## Schedule of updated planning drawings and reports following amendments to facilitate Ball Strike Netting and other minor alterations

DRAWING NUMBER: 22315-ALA-00-XX-DR-L-0008
STATUS: S2
REVISION: P10

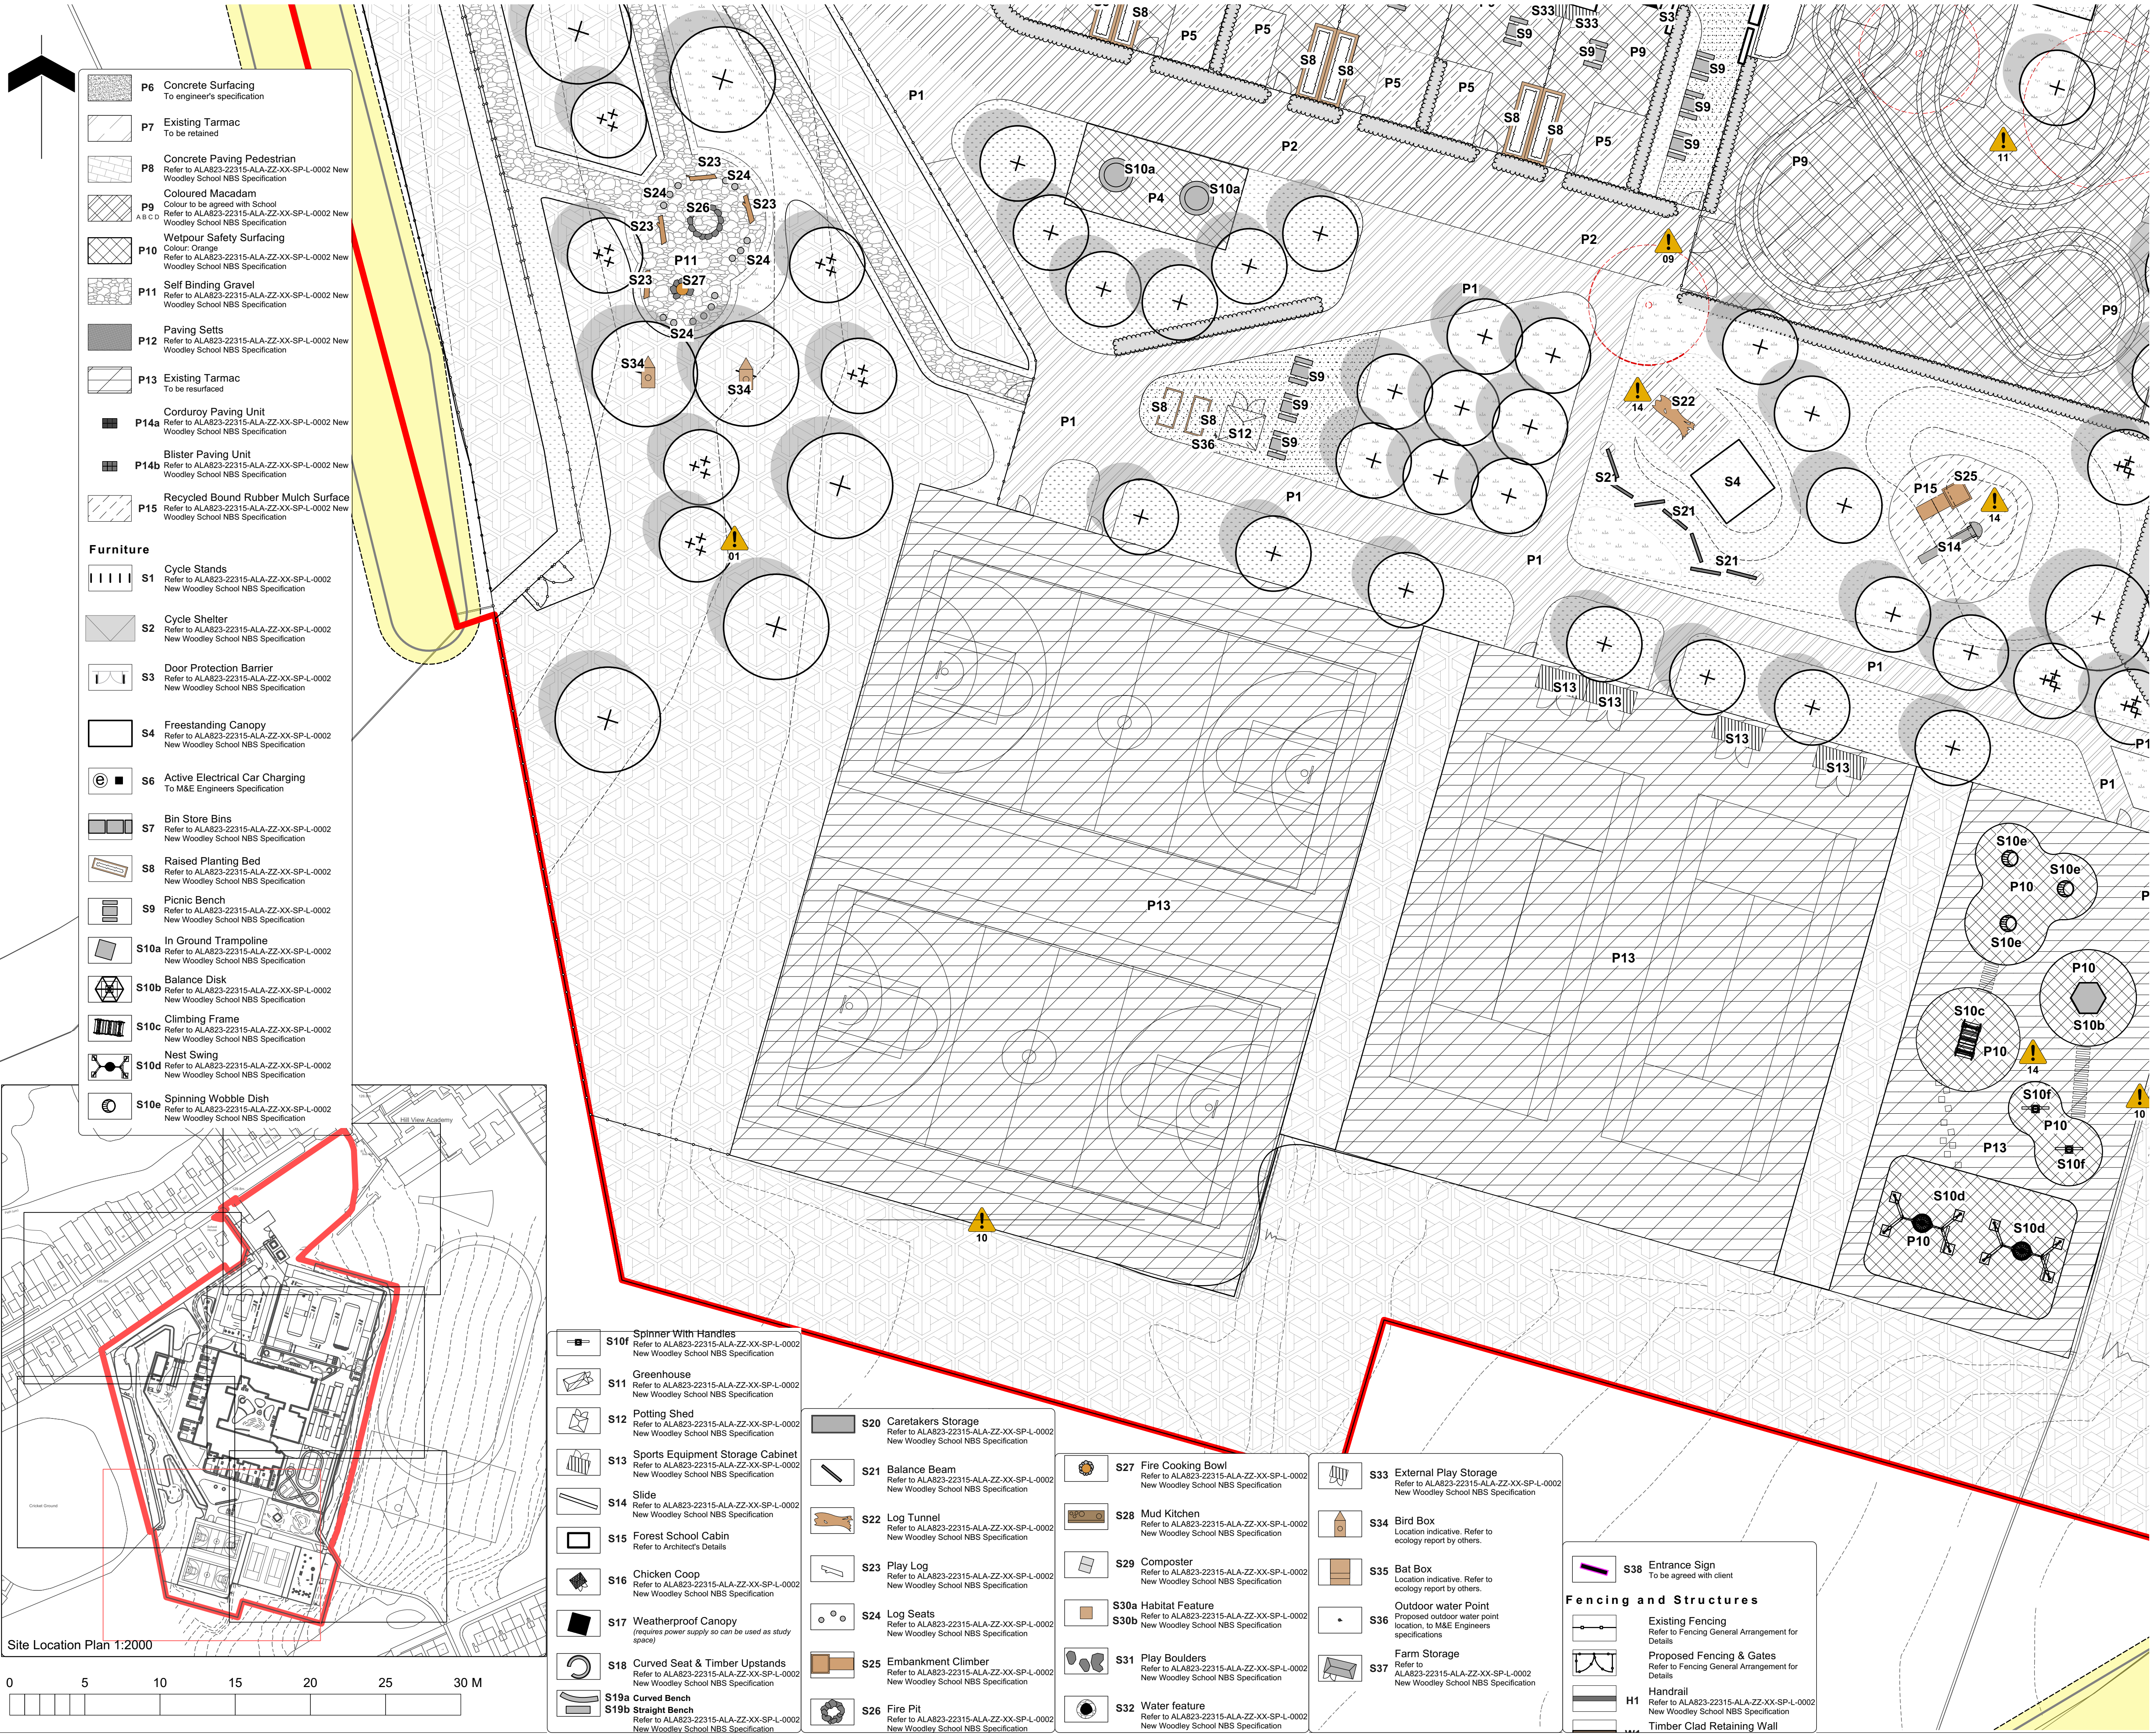
Plan	Reference	Updated drawing	Description of amendments
			10.N note amended to remove reference to relocated Forest School Cabin.
Detailed Landscape General Arrangement Plans (Sheets 1 – 6)	<p>22315-ALA-00-XX-DR-L-0004 rev. P03</p> <p>22315-ALA-00-XX-DR-L-0006 rev. P03</p> <p>22315-ALA-00-XX-DR-L-0007 rev. P03</p> <p>22315-ALA-00-XX-DR-L-0008 rev. P03</p> <p>22315-ALA-00-XX-DR-L-0009 rev. P03</p> <p>22315-ALA-00-XX-DR-L-0011 rev. P02</p>	<p>22315-ALA-00-XX-DR-L-0004 rev. P11</p> <p>22315-ALA-00-XX-DR-L-0006 rev. P10</p> <p>22315-ALA-00-XX-DR-L-0007 rev. P10</p> <p>22315-ALA-00-XX-DR-L-0008 rev. P10</p> <p>22315-ALA-00-XX-DR-L-0009 rev. P11</p> <p>22315-ALA-00-XX-DR-L-0011 rev. P09</p>	<p><u>22315-ALA-00-XX-DR-L-0004</u> Re-issued for planning following Sport England objection withdrawal. Changes as follows: 1.Substation relocated and pedestrian entrance route. 2.Swale length adjusted to avoid conflict with adjacent paving.</p> <p><u>22315-ALA-00-XX-DR-L-0006</u> Re-issued for planning following Sport England objection withdrawal. Changes as follows: 1.Play item locations adjusted to account for critical fall distances. 2.Entrance sign proposed.</p> <p><u>22315-ALA-00-XX-DR-L-0007</u> Re-issued for planning following Sport England objection withdrawal. Changes as follows: 1.Play item locations adjusted to account for critical fall distances. 2.Reinforced grass proposed to start and finish of natural play features. 3.Play mound levels amended, with play furniture rearranged to suit.</p> <p><u>22315-ALA-00-XX-DR-L-0008</u> Re-issued for planning following Sport England objection withdrawal. Changes as follows: 1.Ball Stop netting added, hedge removed, and Forest School area updated. 2.Play item locations adjusted to account for critical fall distances. 3.Reinforced grass proposed to start and finish of natural play features.</p>

Plan	Reference	Updated drawing	Description of amendments
			<p>4.Play mound levels amended, with play furniture rearranged to suit.</p> <p><u>22315-ALA-00-XX-DR-L-0009</u> Re-issued for planning following Sport England objection withdrawal. Changes as follows: 1.Ball Stop netting added, hedge removed, and Forest School area updated. 2.Terracing and slide to Forest School amended. 3.Play item locations adjusted to account for critical fall distances. 4.Horticulture area adjusted to latest Forest School Cabin layout, with 2no. Play Stores added.</p> <p><u>22315-ALA-00-XX-DR-L-0011</u> Re-issued for planning following Sport England objection withdrawal. Changes as follows: 1.Terracing and slide to Forest School amended. 2.Play item locations adjusted to account for critical fall distances. 3.Horticulture area adjusted to latest Forest School Cabin layout, with 2no. Play Stores added. 4.Swale length adjusted to avoid conflict with adjacent paving.</p>
